CITY OF ALBUQUERQUE

PLANNING DEPARTMENT – Development Review Services

January 6, 2015

RE: Alameda Self Storage (C18D064A)
Grading and Drainage Plan
Supplemental Information, Engineer's Stamp Date 12-15-2014

GRADING AND DRAINAGE PLAN

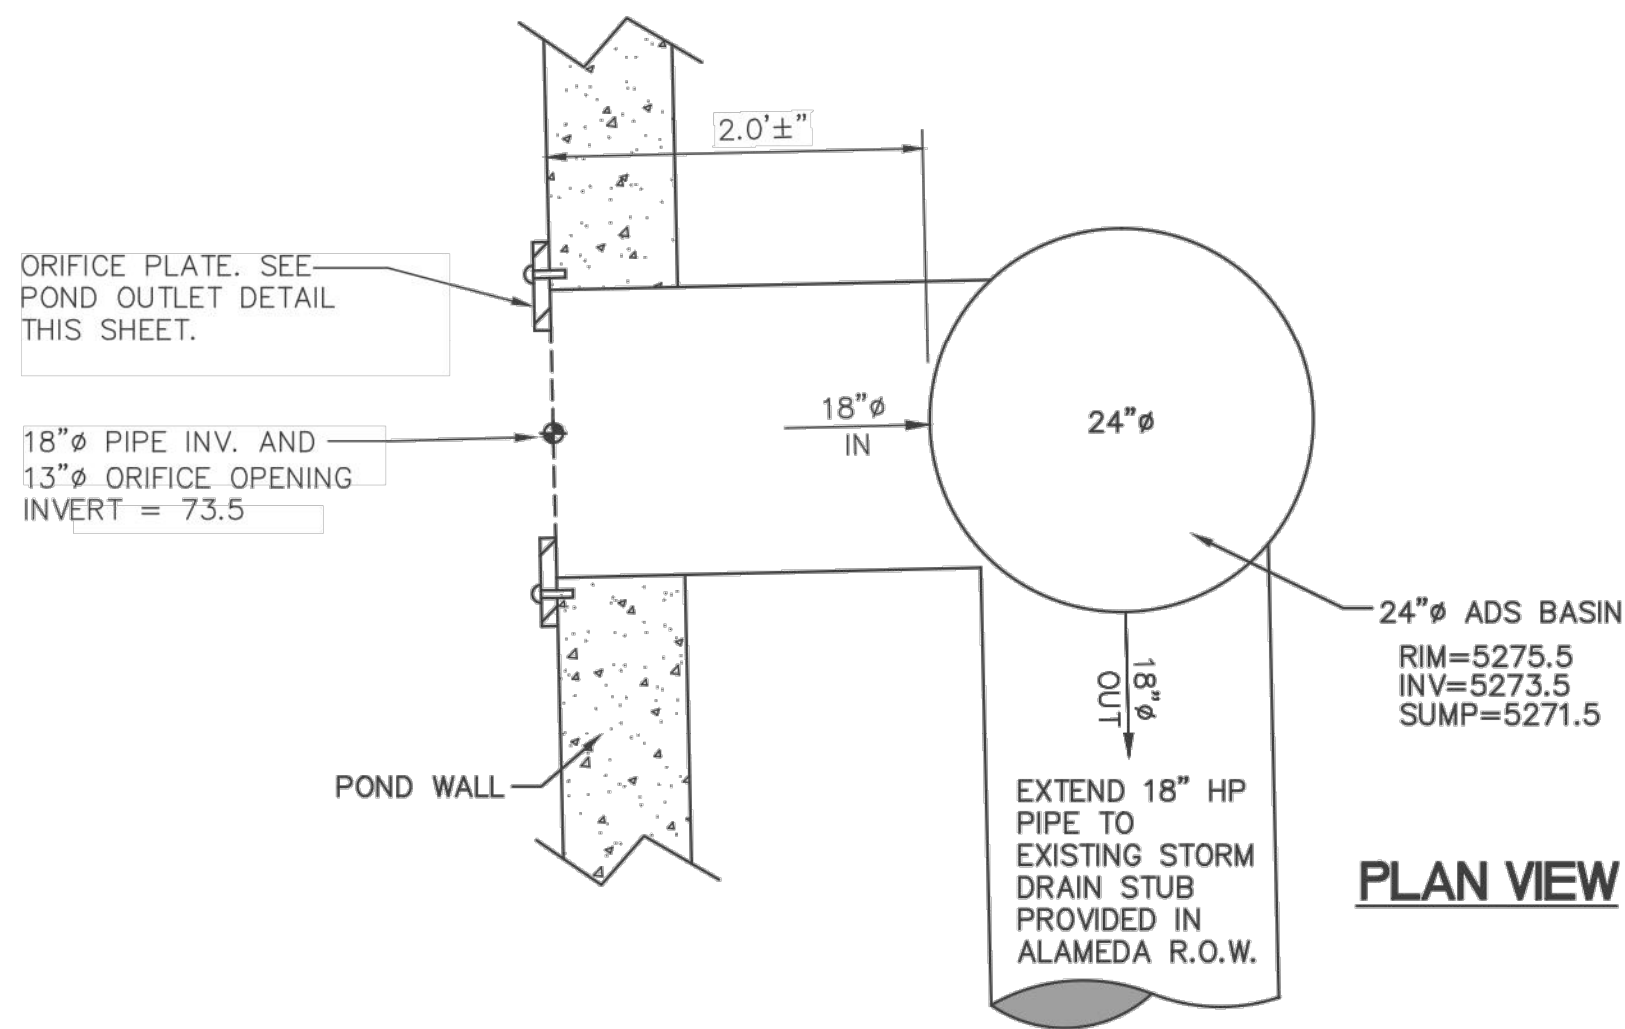
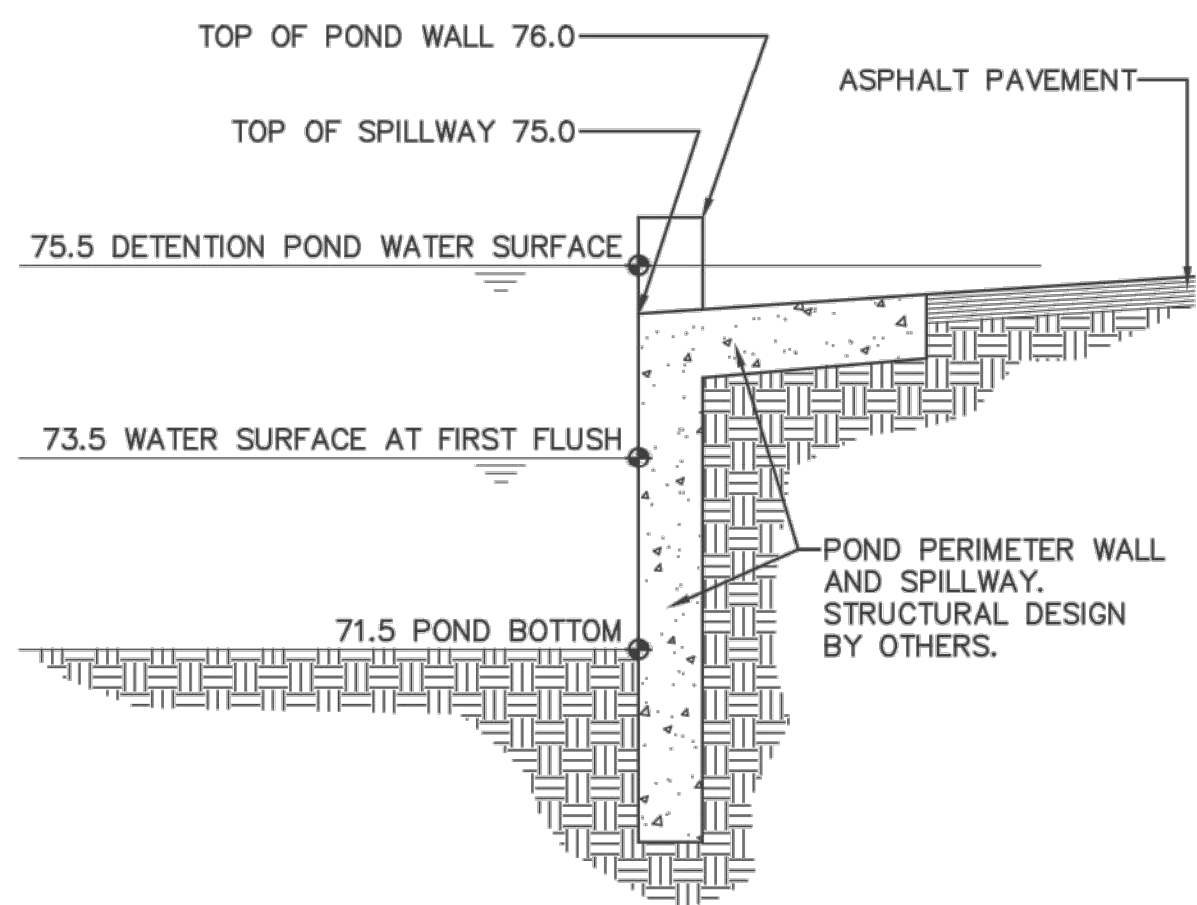
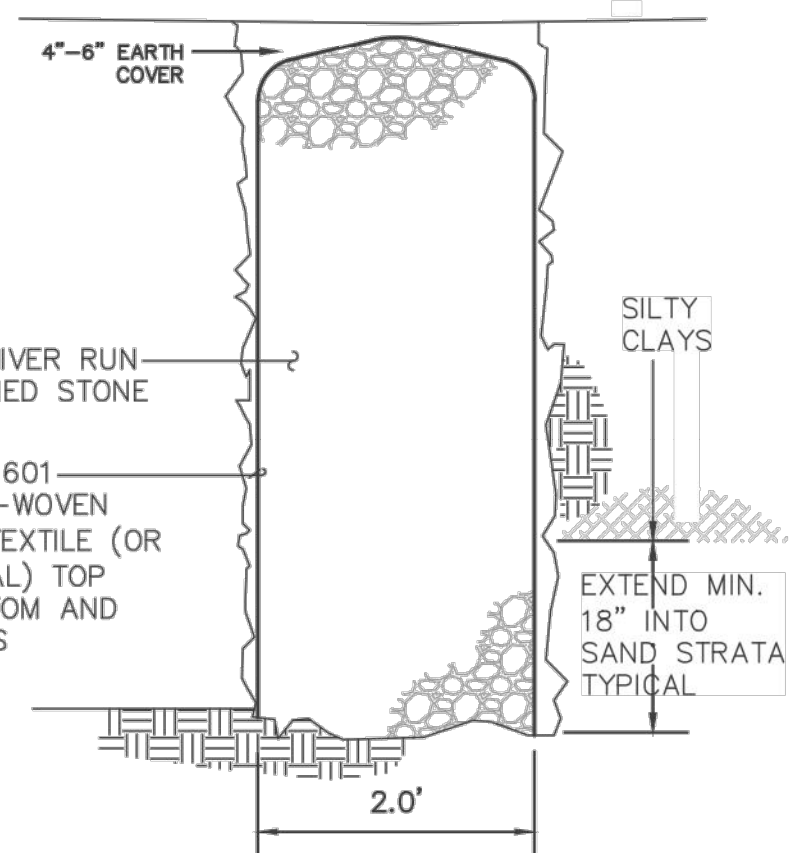
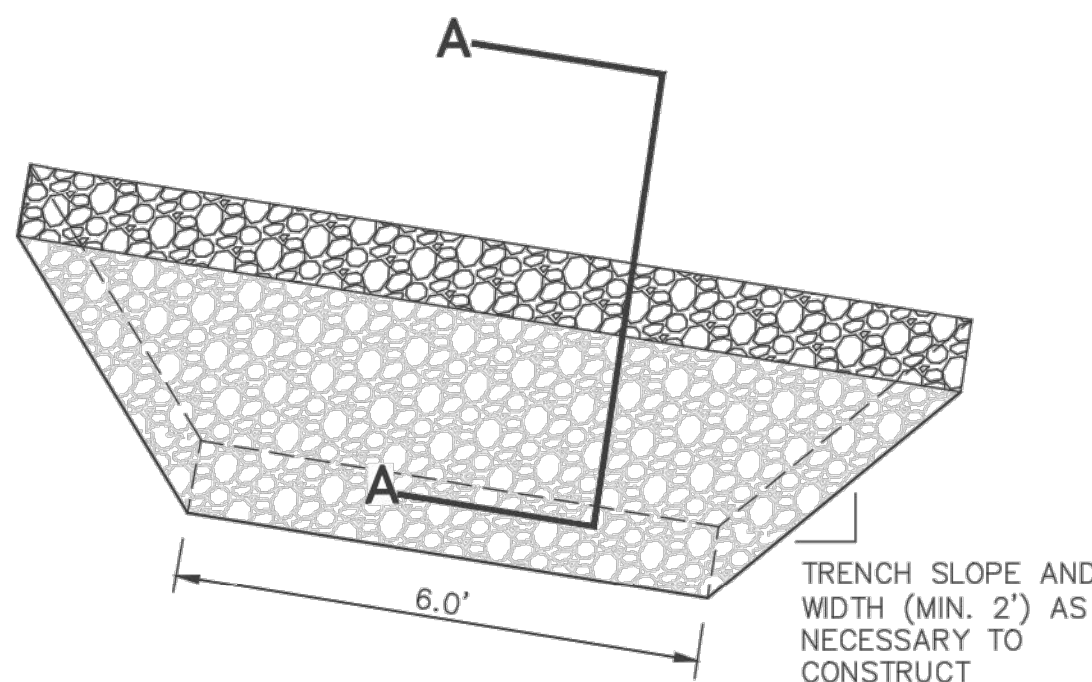
6. Show the connection detail from the 18" dia RCP stub to the 18" Dia ADS pipe.
7. Provide Alameda As-builts showing location and elevations of existing inlet, and the SD infrastructure.

11. There needs to be a foot of freeboard at the pond. If the pond overtops, can the existing wall on the north, south, and west side of the pond contain the pond if the WSEL is 1 ft higher? Is it a concrete block wall?
12. The volume is calculated for the 6 hr. storm, but volume should be based on the on the design storm equal to or exceeding the evacuation time. What is the evacuation time of the pond?
13. Provide a section cut detail for the concrete spillway.
14. Indicate the Pond Volume, WSEL on the plans.

FULLY DEVELOPED - SEE SHEET C-2 FOR PHASE I TEMPORARY RETENTION POND

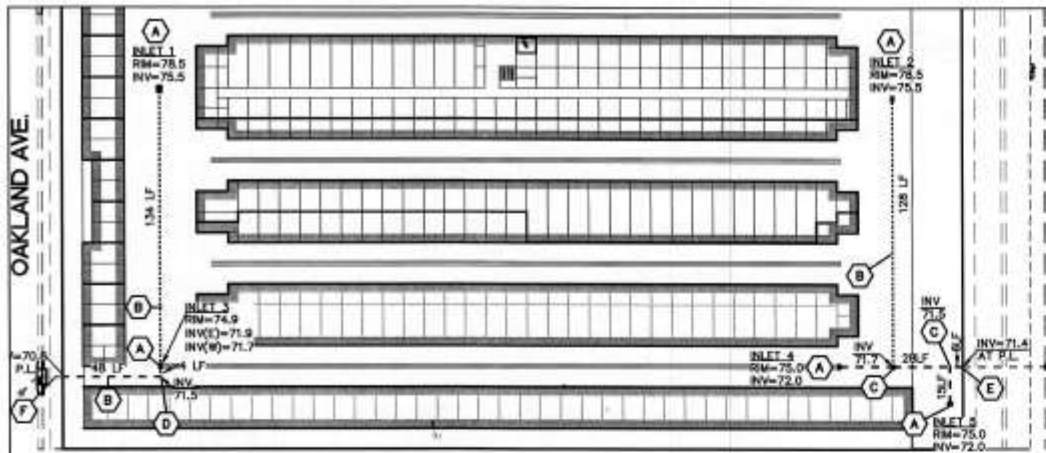
1. This plan is not consistent with the Fully Developed plan dated 5-16-05. Show how the fully developed condition is intended to change by sketching in the new building and crossing out the planned future building on the Fully Developed plan, which shows the overall site.
